Ms Kay Sully,
The Planning Inspectorate,
National Infrastructure Planning,
Temple Quay House,
2, The Square,
Bristol,
BS1 6NP

Wylfa Newydd DCO Examination EN010007 - Deadline 8 Submissions.

Figure 2-1 Indicative Construction Timeline

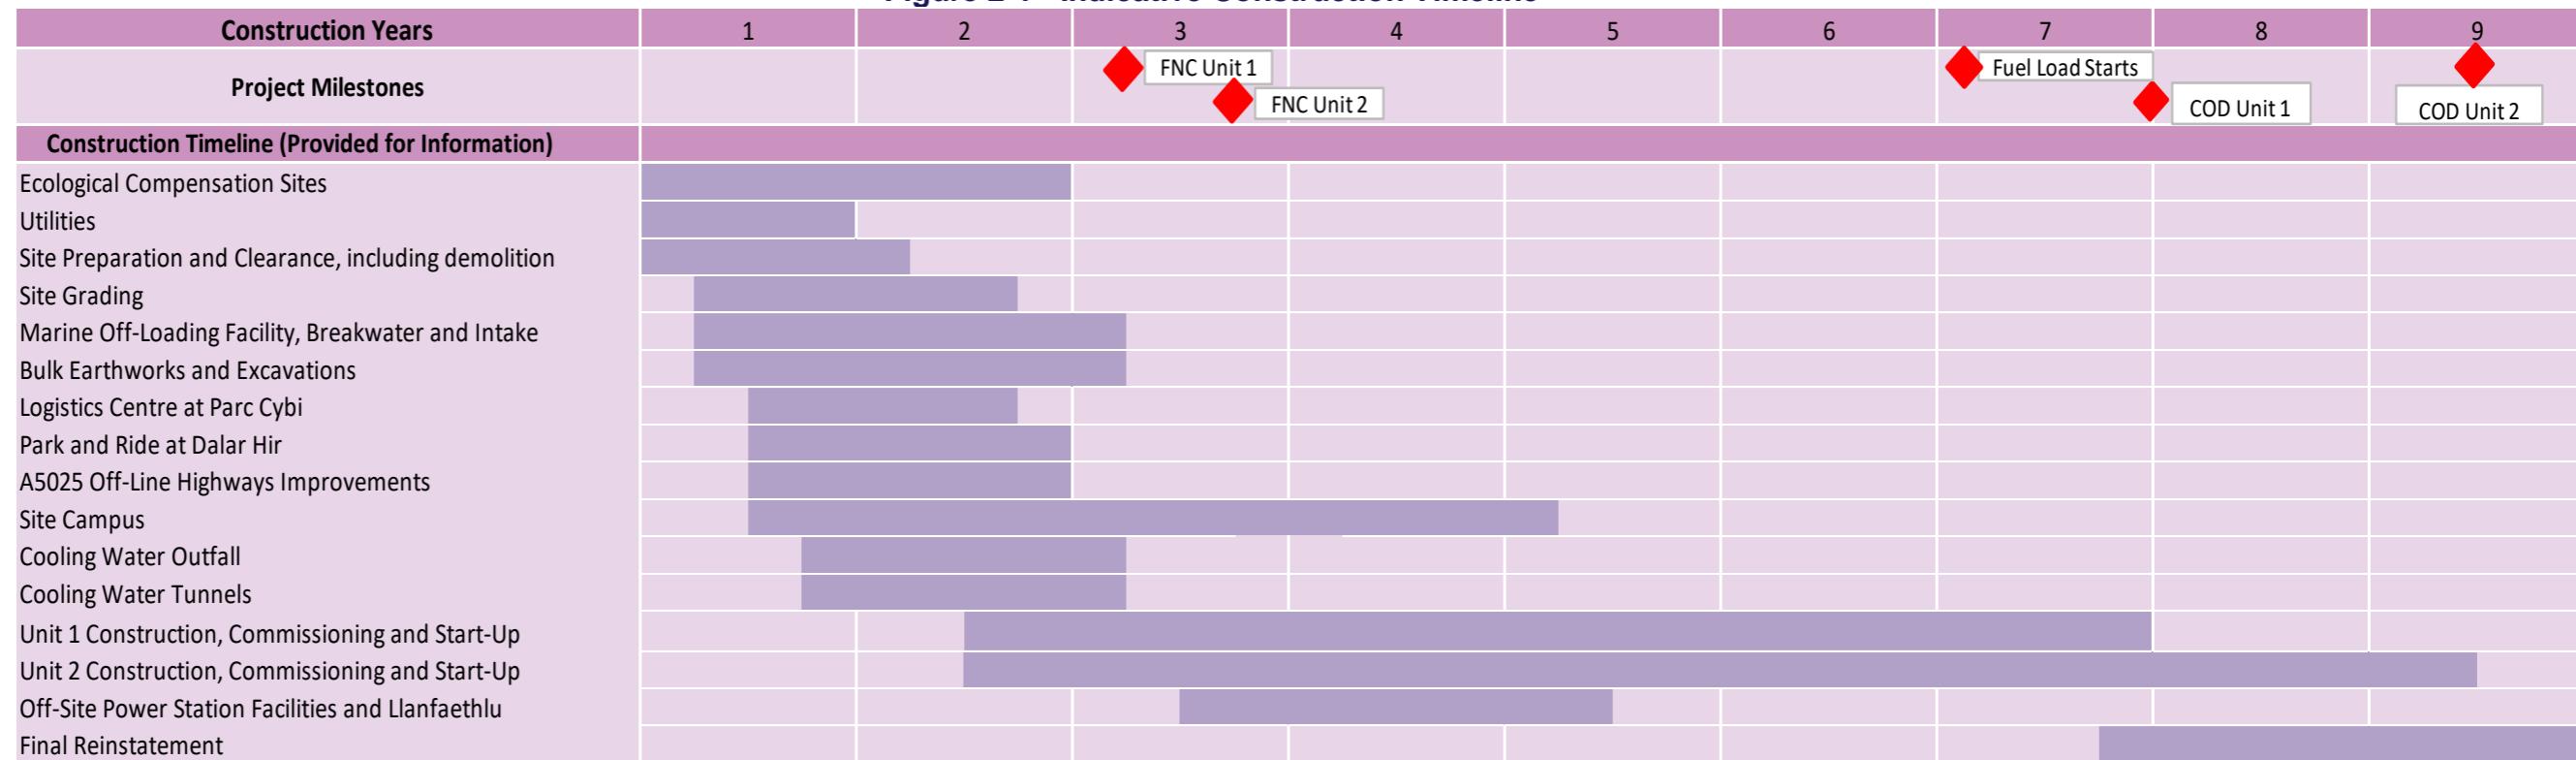
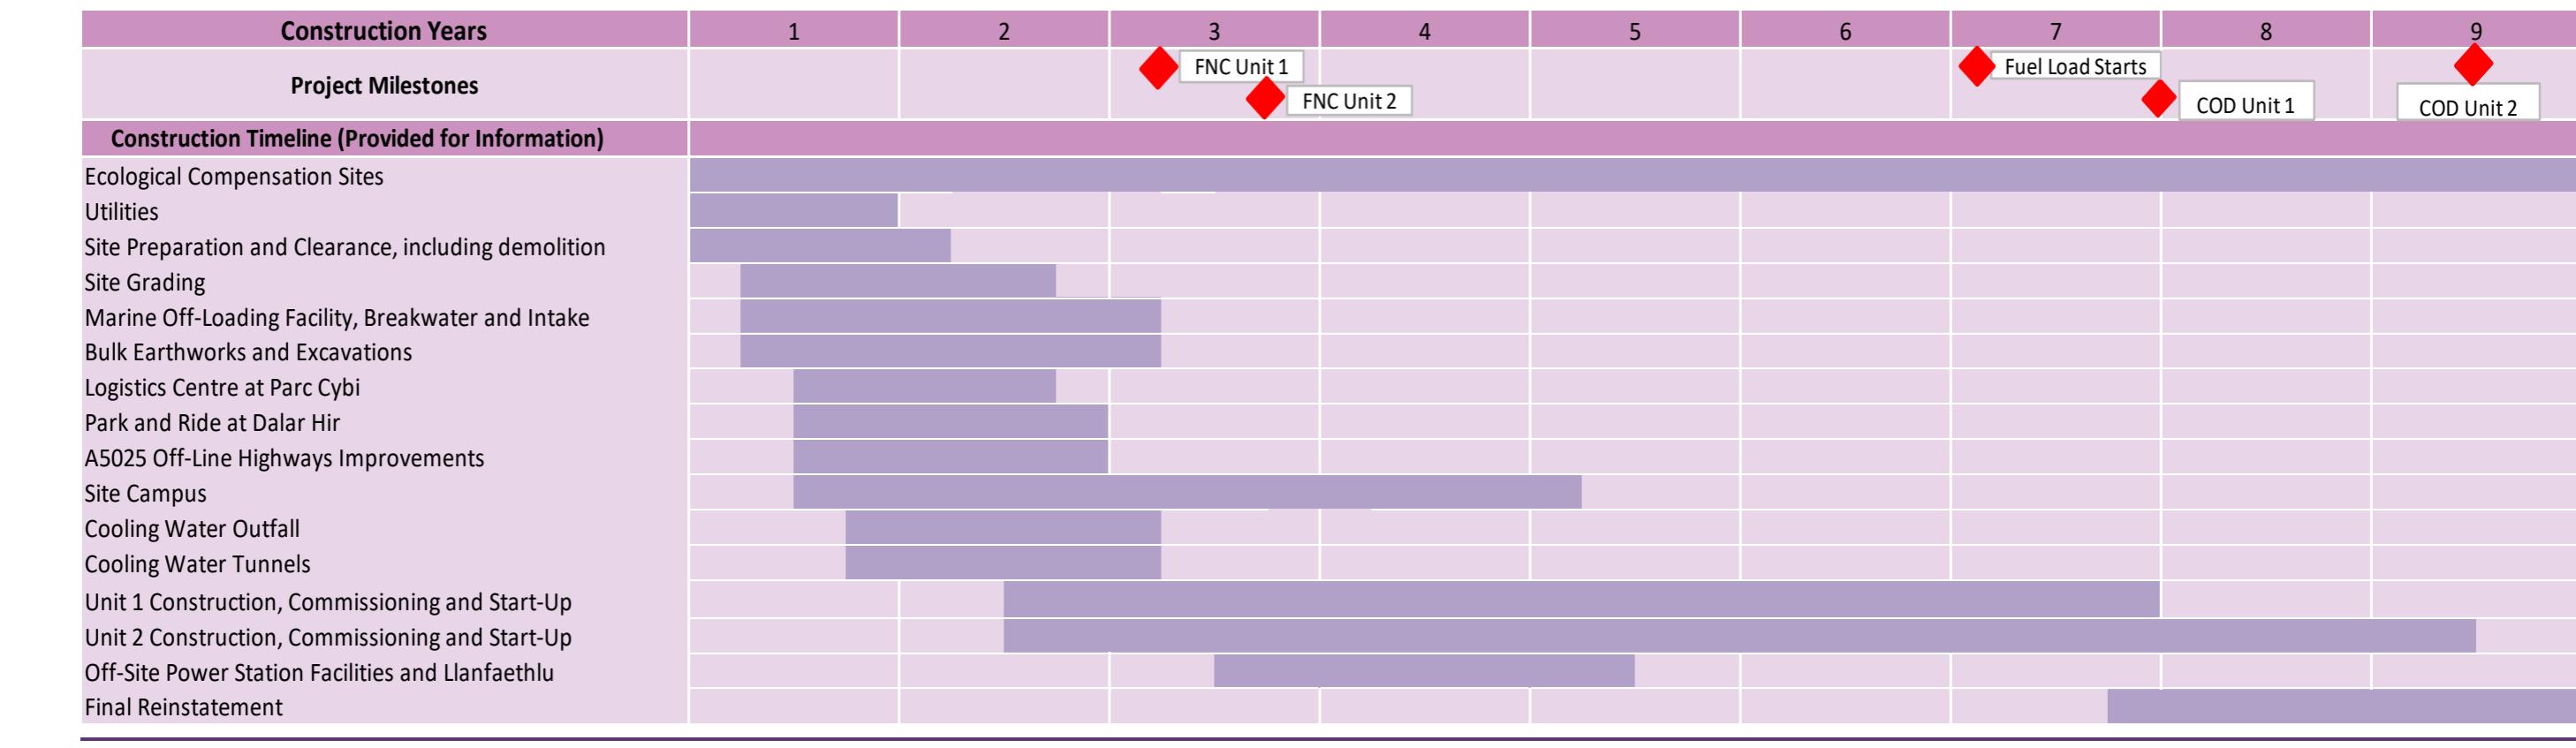
IACC has received a revised Phasing Strategy from HNP following the March ISH and has provided comments. In summary, whilst we believe that the revised Phasing Strategy is clearer in terms of its role and purpose (i.e. in delivering the key mitigations), concerns remain due to the discrepancy between the indicative phasing (Figure 2-1) and the proposed triggers.

The IACC has requested but not received further detail on the thresholds and when they are likely to be triggered. As confirmed IACC during the March ISH hearings, the Councils requires the inclusion of clear milestones (years and quarters) for each of the key mitigations to ensure that they are delivered on time to mitigate the impacts. Indicative Phasing with conflicting triggers is not acceptable.

IACC therefore requests that the following amendments are made to table 2.2 of the Phasing Strategy in relation to confirming the timing for delivery (triggers) and pre-delivery restrictions;
